DEVELOPMENT REVIEW BOARD
TRANSPORTATION DEVELOPMENT

DRB Project Number: 1004428
Ceja Vista Subdivision

SUBJECT: Amended Preliminary Plat

DRB Project Number: 1004428 Hearing Date: 4-18-2018
 Project: Ceja Vista, Tracts RR-3-A, RR-3-B, RR-3-C, RR-3-D, & RR-3-E Agenda Item No: 11

26' FF Res. Pvmnt Pita Verde Stub Potrero Dr. Tract L

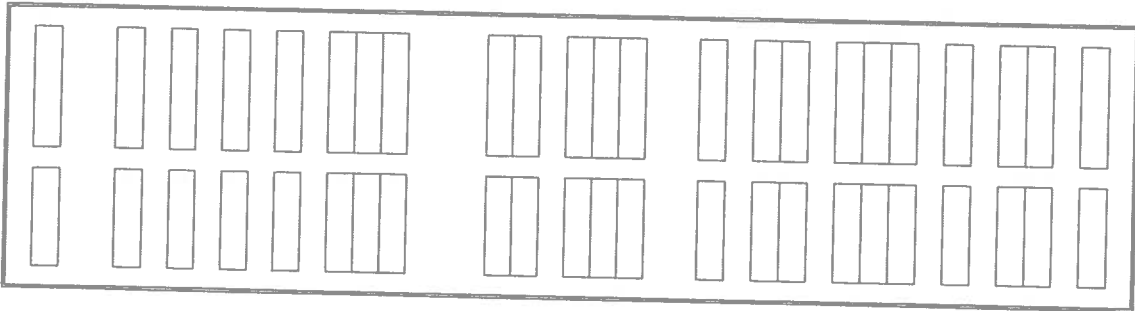
11. Provide a 6' SW connection thru tracts J & K.
12. Portero & Pita Verde stub street – sidewalk cannot be waived per the DPM.
13. Adjust cross section #5 of Paraje to include SW on both sides.

AMENDED PRELIMINARY PLAT FOR
CEJA VISTA SUBDIVISION
UNITS 1 A, 1 B, 1 C, 2 AND 3
 WITHIN THE
TOWN OF ATRISCO GRANT
 PROJECTED SECTION 9
 TOWNSHIP 9 NORTH, RANGE 2 EAST, NMPM
 CITY OF ALBUQUERQUE
 BERNALILLO COUNTY, NEW MEXICO
 DECEMBER, 2017

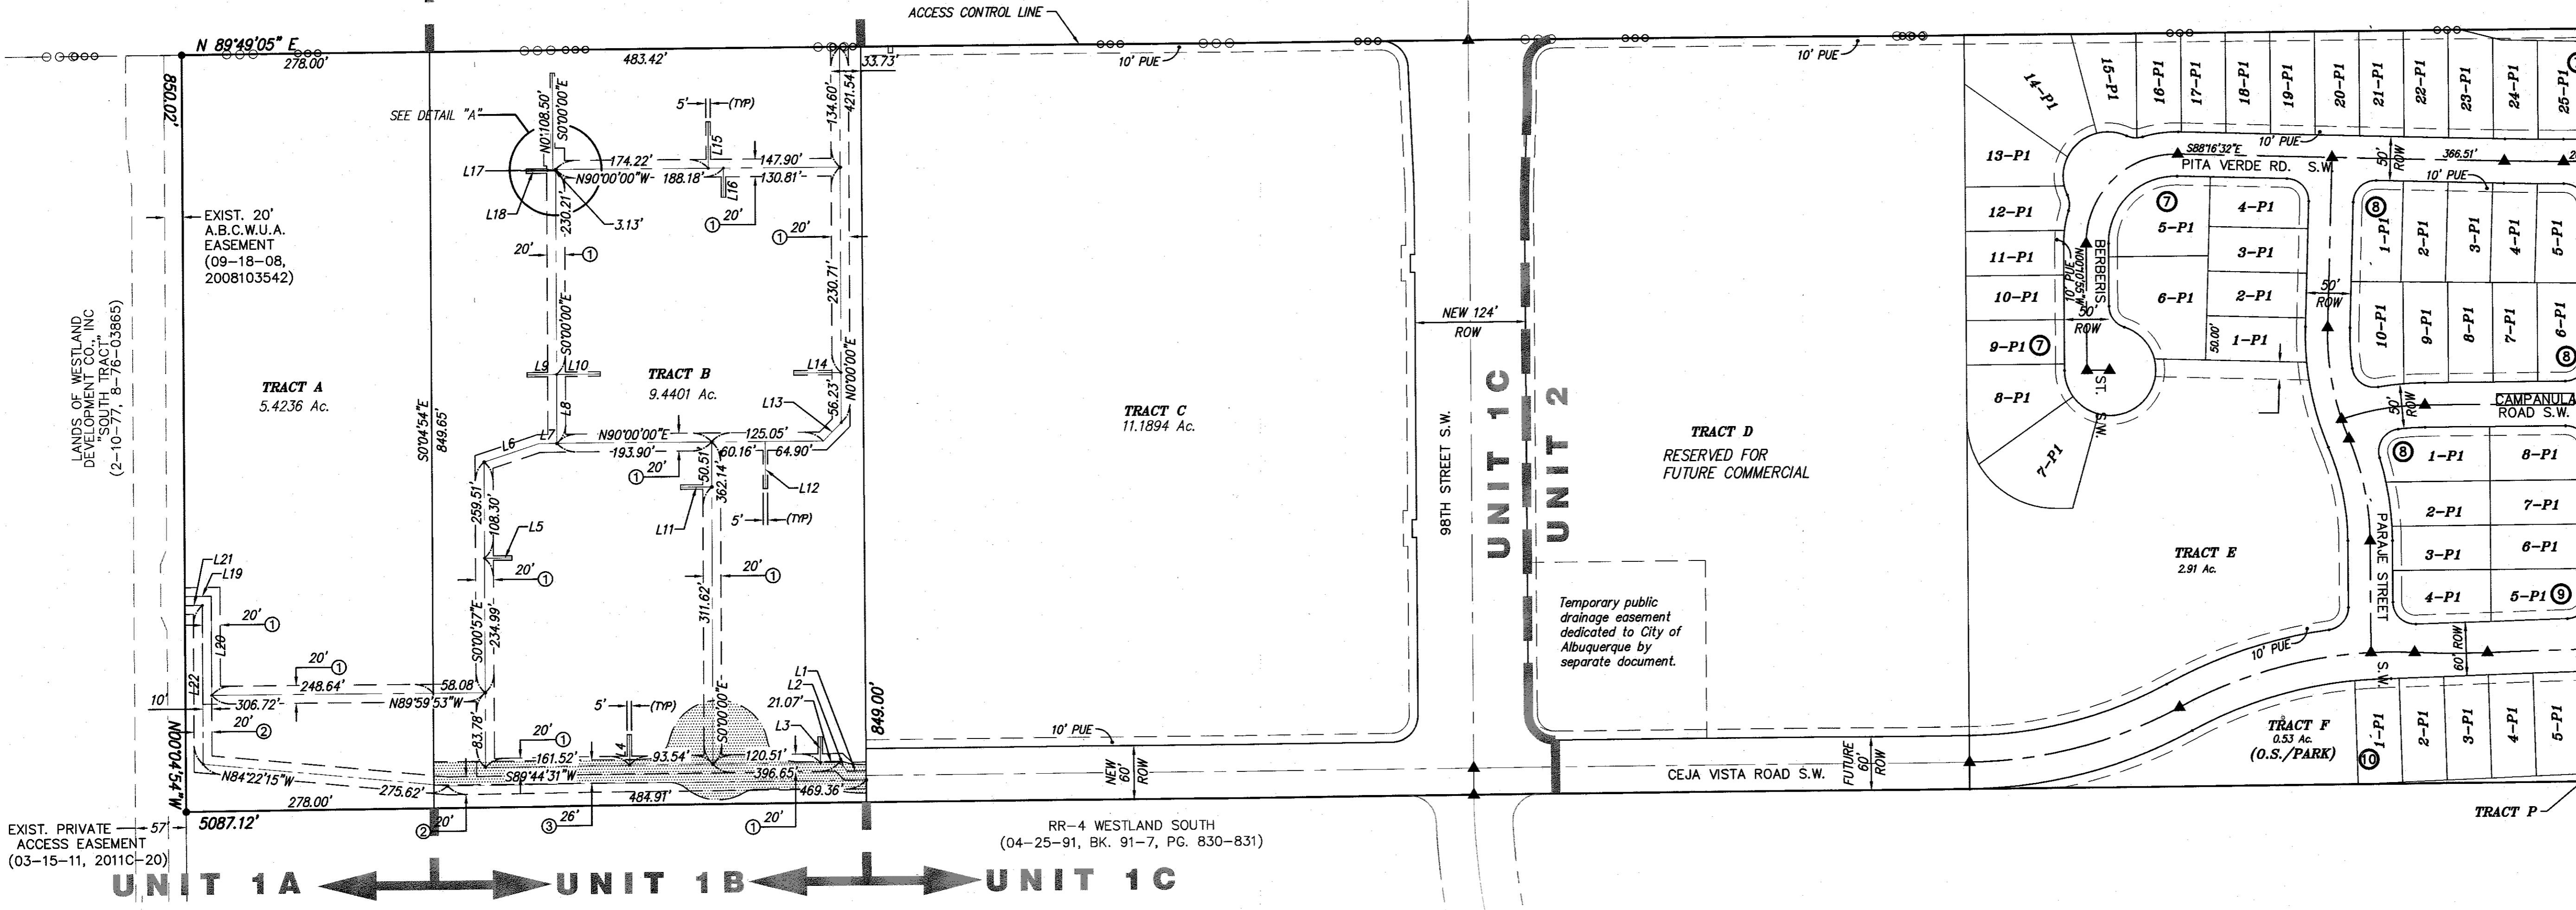
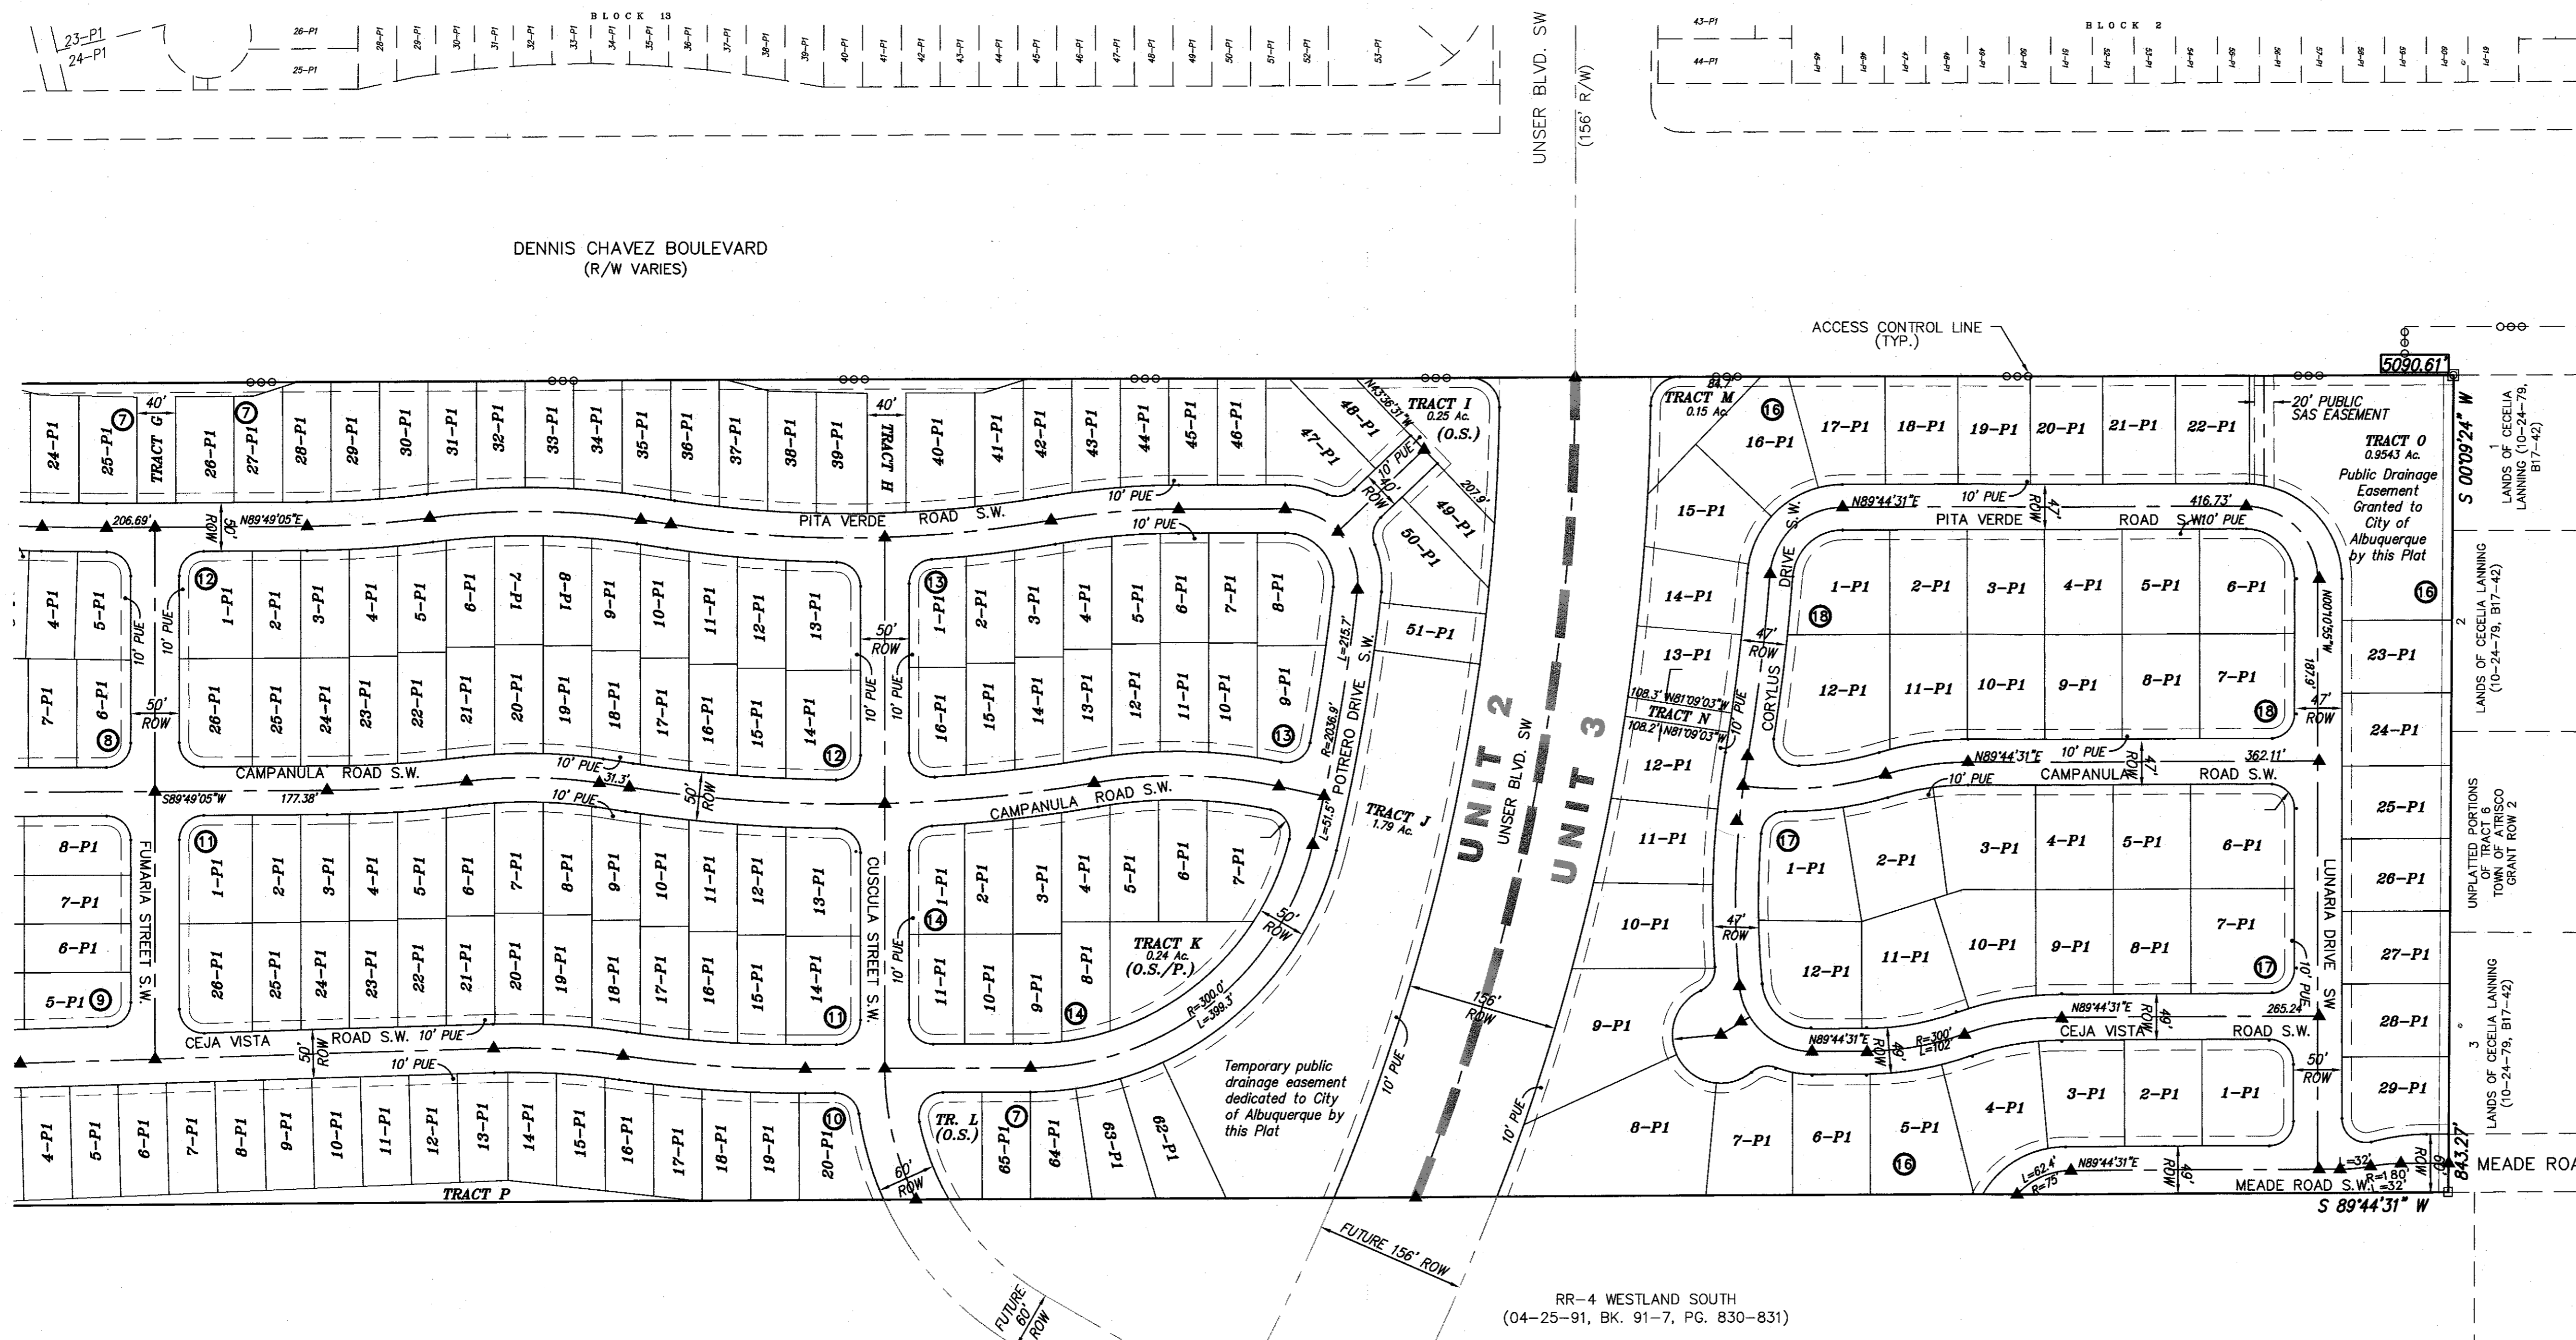
1. Lots and tracts on Plat and Infrastructure List must match.
2. Remove "Future" labels from plat.
3. Turn around easement on tracts C and G need to be either 96' cul-de-sac or 120' hammerhead/ modified hammerhead.

4. Show public access easement for fire access to Tract B.
5. Access easement across south part of tract B needs to be wider. The layout does not match between sheet 1, 2, and detail on sheet 2.
